FW: 20079 - Dappers Lane Planning Consultation on: A/188/21/DOC

Further to your recent review of our information required to discharge planning conditions, we are pleased to provide the updated information on the following link; <https://we.tl/t-Os1XI0r1nn>.

Scale	1:20 @ A1	Drawn	WJL
Date	Oct 2020	Checked	LH
File	dwg/civils/current	Drawing	20079 / 330 B

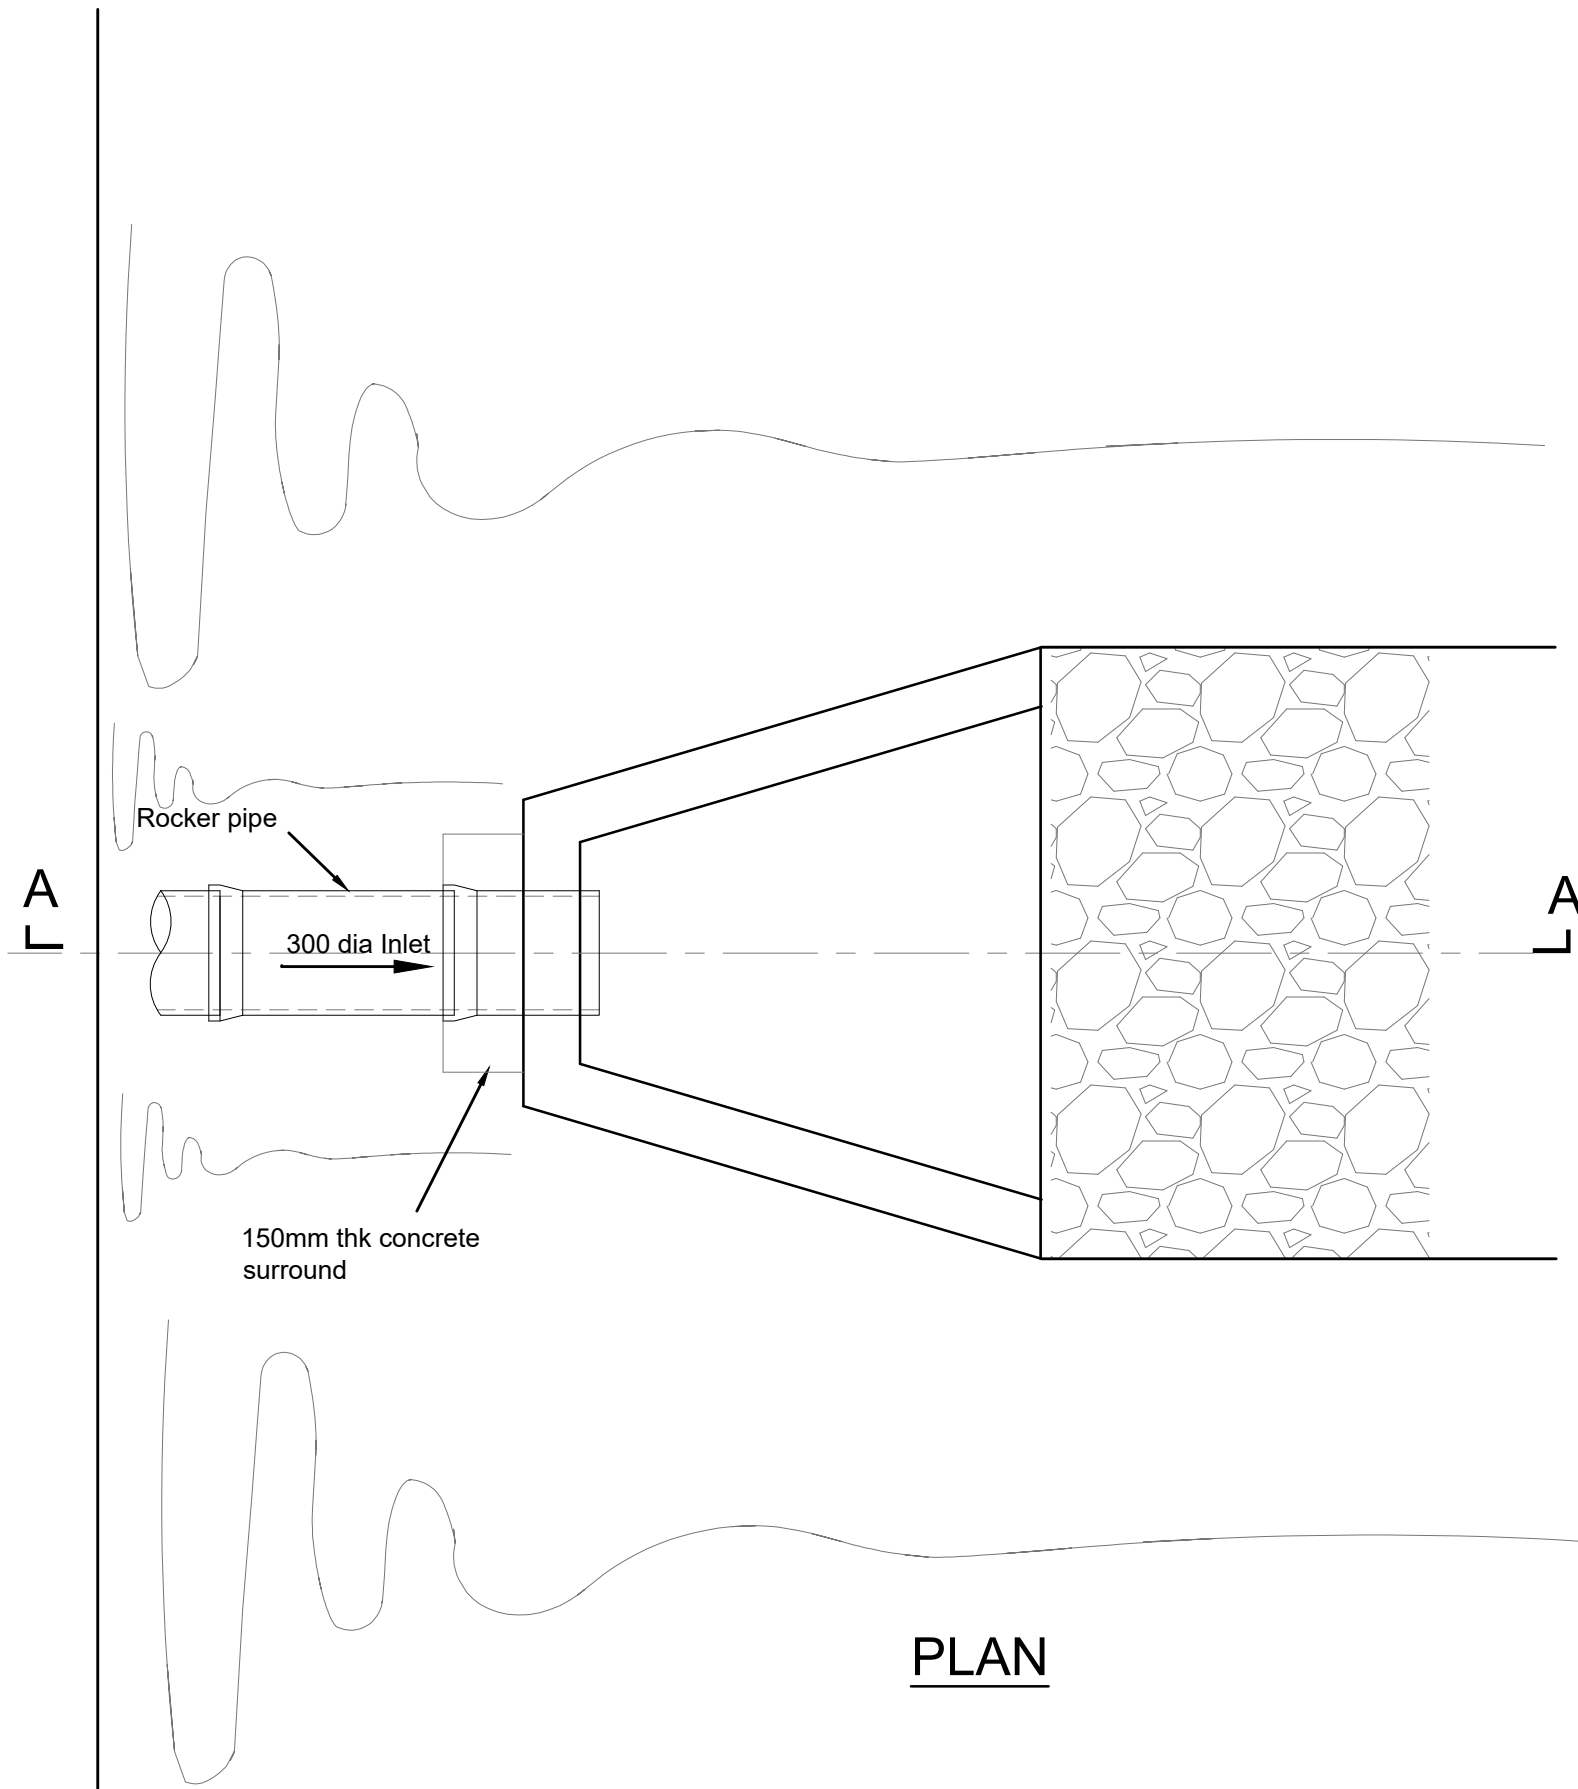
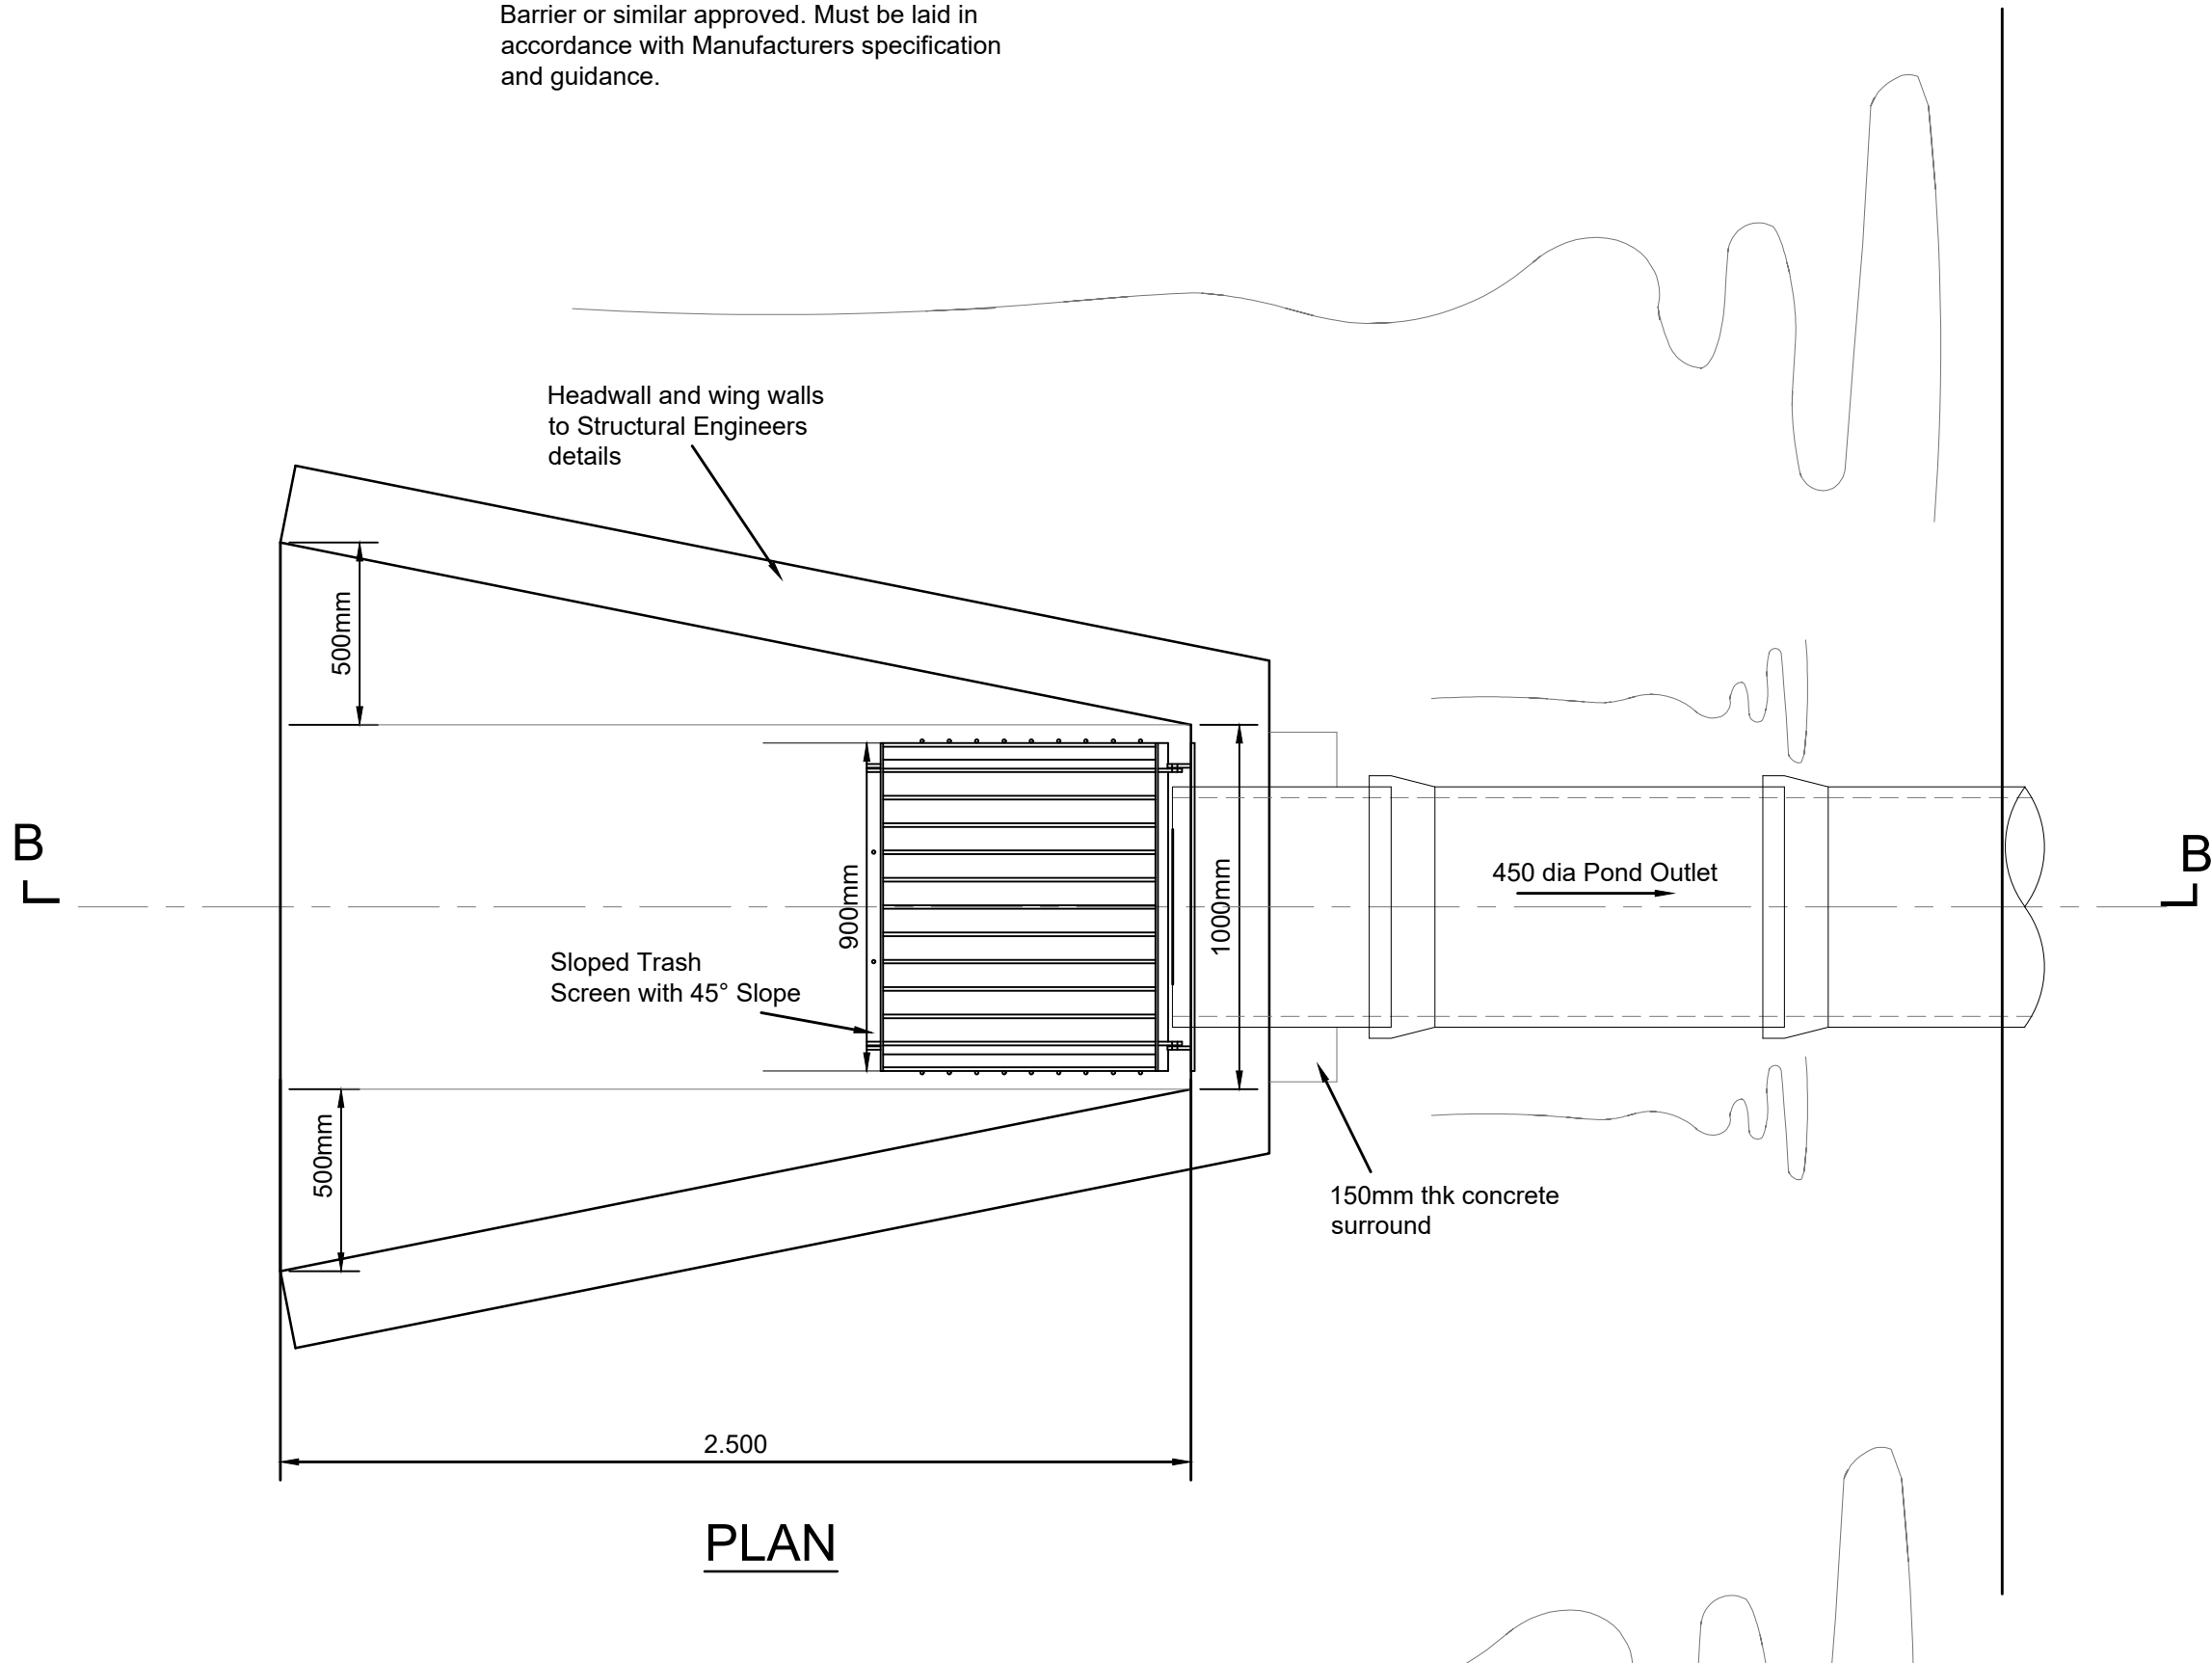
15. Please provide full construction detail drawings. Please provide construction detail drawings of catchpits, ACO drains, permeable paved roads, etc.

BGC 30/08/21 – Full set of Construction Details provided within latest submission including ACO drains and permeable paved roads. Please refer to drawings; 20079/311, 20079/315, 20079/316, 20079/320, 20079/321, 20079/322, 20079/326, 20079/327, 20079/330 & 20079/331.
